**DELEGATED DECISION TO DETERMINE APPLICATIONS FOR
NON-MATERIAL AMENDMENTS**

Reference No: **2023/NM/92838/E**

Site Address: Land adj, Inkerman Court, Barnsley Road, Denby Dale, Huddersfield, HD8 8XA

Description: Non-material amendment to previous approval (ref: 2023/90066) of variation of conditions 2 (plans) and 6 (highway layout) of previous permission 2019/91836 for erection of 34 dwellings

SUB STATION - BARNESLEY ROAD, DENBY DALE

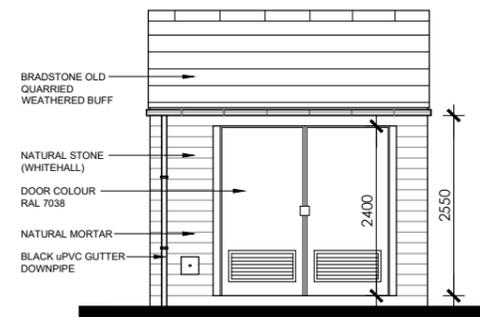
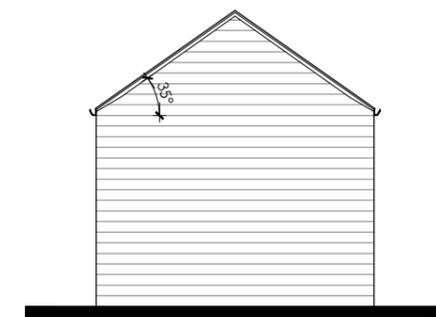
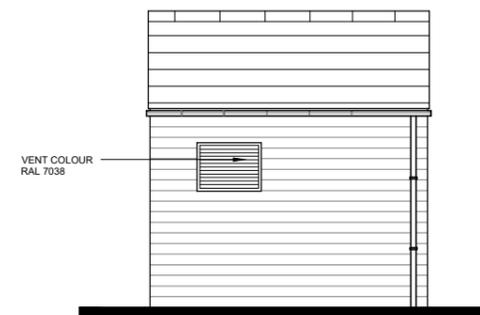
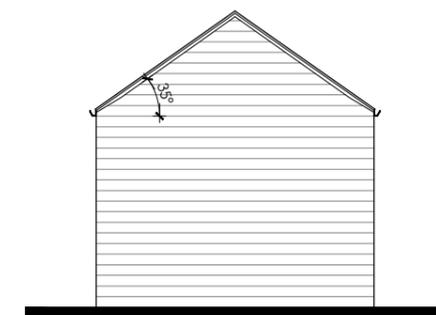
The proposed electricity substation is considered acceptable in design terms. Its materials would match those of the development's dwellings (and the relevant condition regarding materials would apply to this recently-proposed building). A pitched roof is proposed (as shown in drawing 1903-SU-01 rev A, although a different roof design is shown in the site layout plan, and a clarifying informative is therefore recommended). A detached garage was previously approved in this location.

Recommendation: Approve (subject to an informative regarding the substation roof design)
